DRAINAGE AND TRANSPORTATION INFORMATION SHEET

PROJECT TITLE: APS Family School East Side

CITY ADDRESS: 3303 Monroe Street NE.

DATE SUBMITTED: 7-12-16

SHEET TITLE:
**EROSION AND
SEDIMENT CONTROL
PLAN**

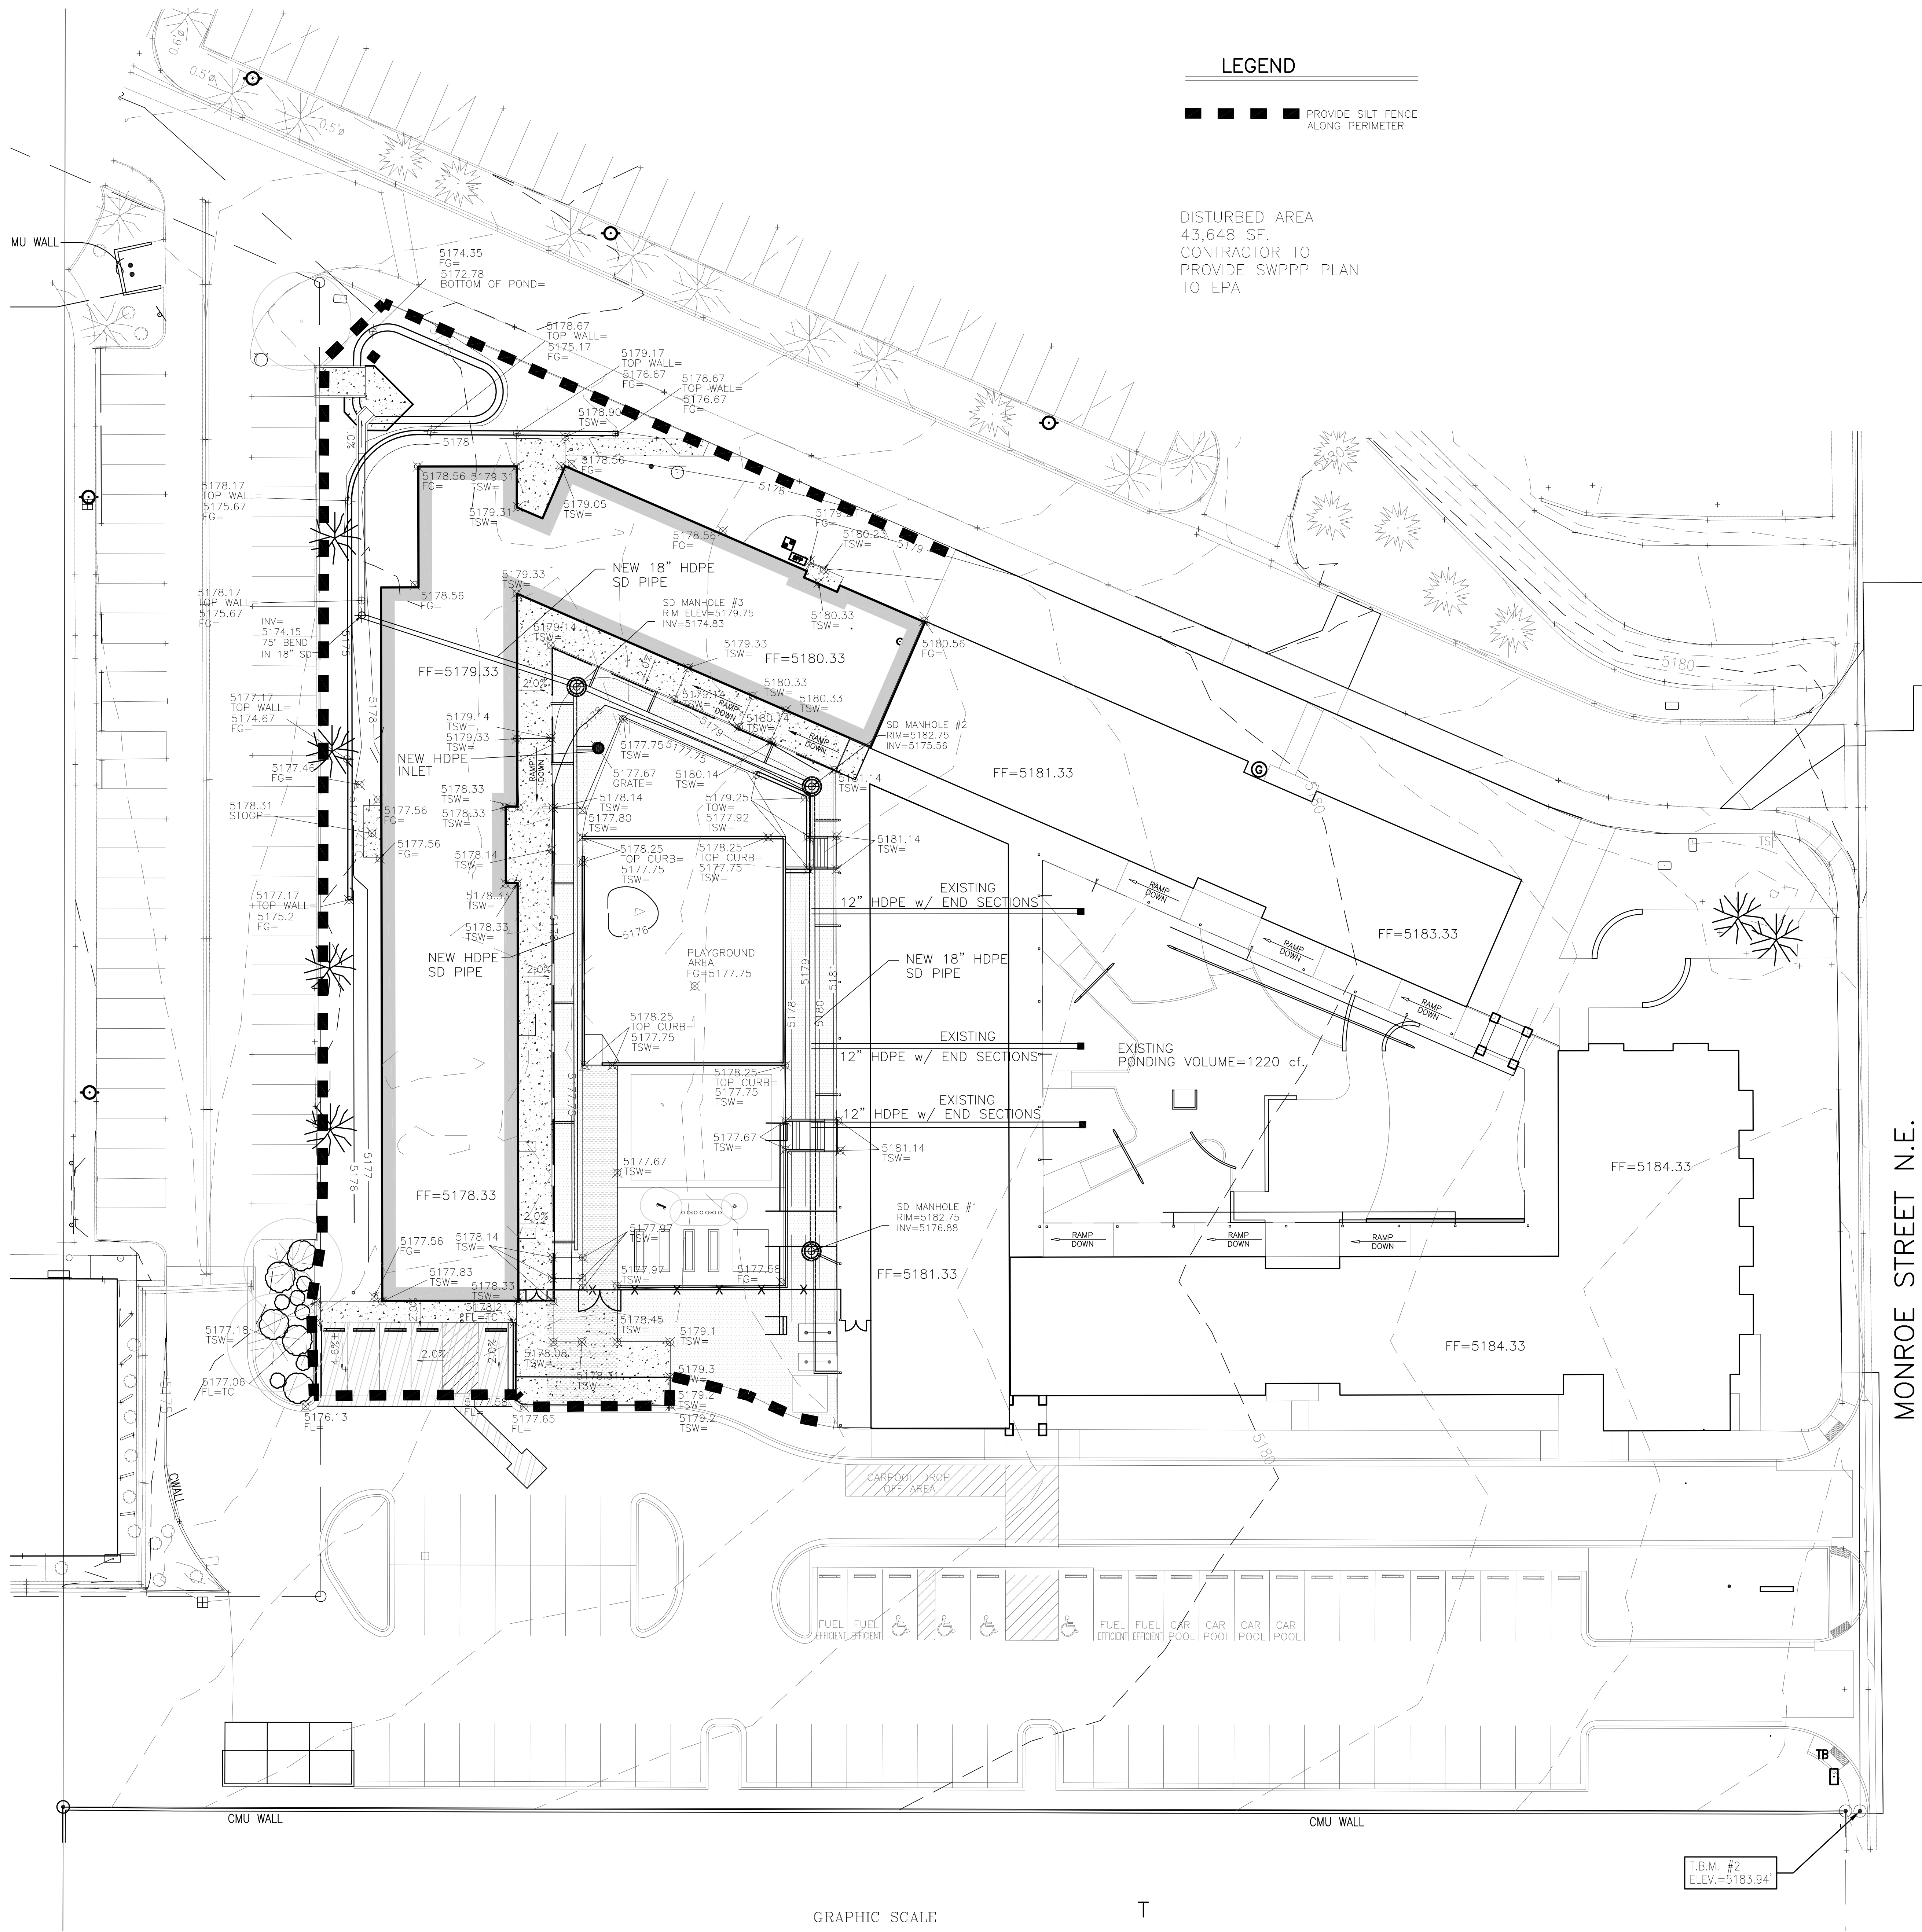
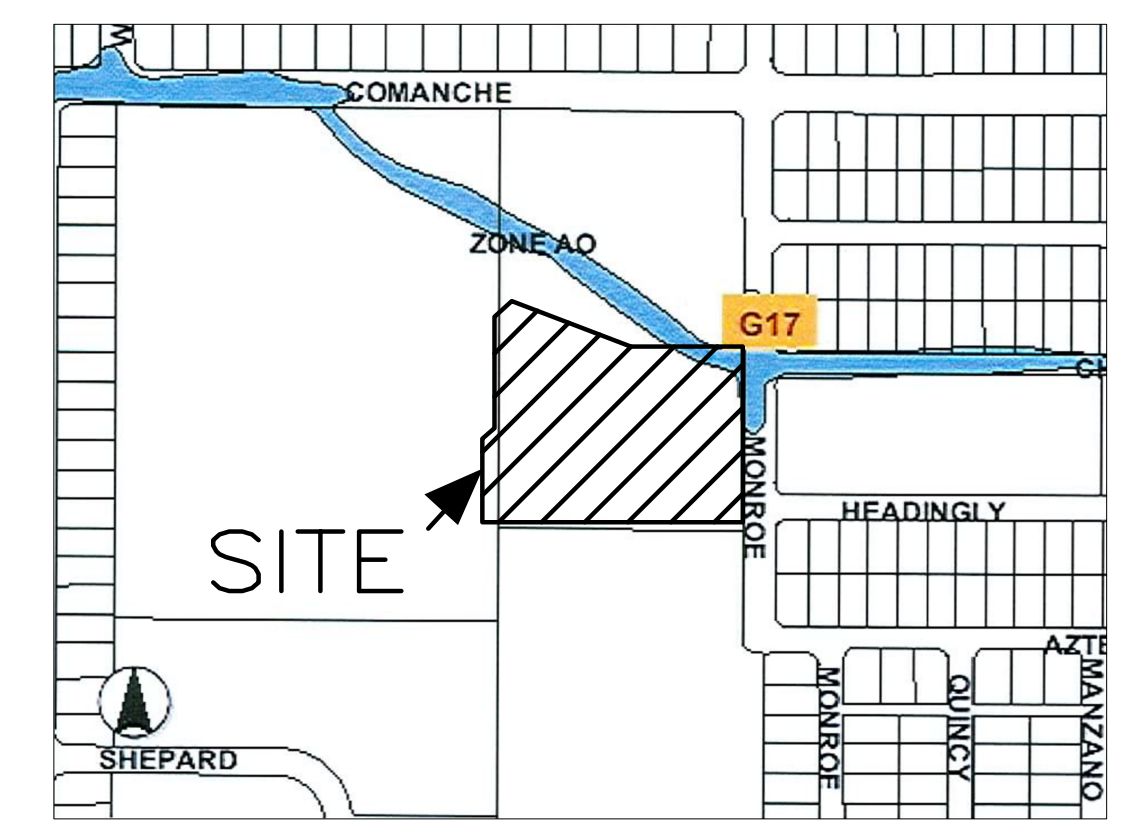
Dave has mark-ups

→ Revise Basin Boundary.

→ Can/should Pond
discharge into other
st. so pedestrians can
cross driveway?

→ provide utility sheet
w/ SD syst. & inlets
NOTE ~~show~~ Roof drain gutter

→ show Roof drain
Points

→ what's new? / existing?

→ label Contrours
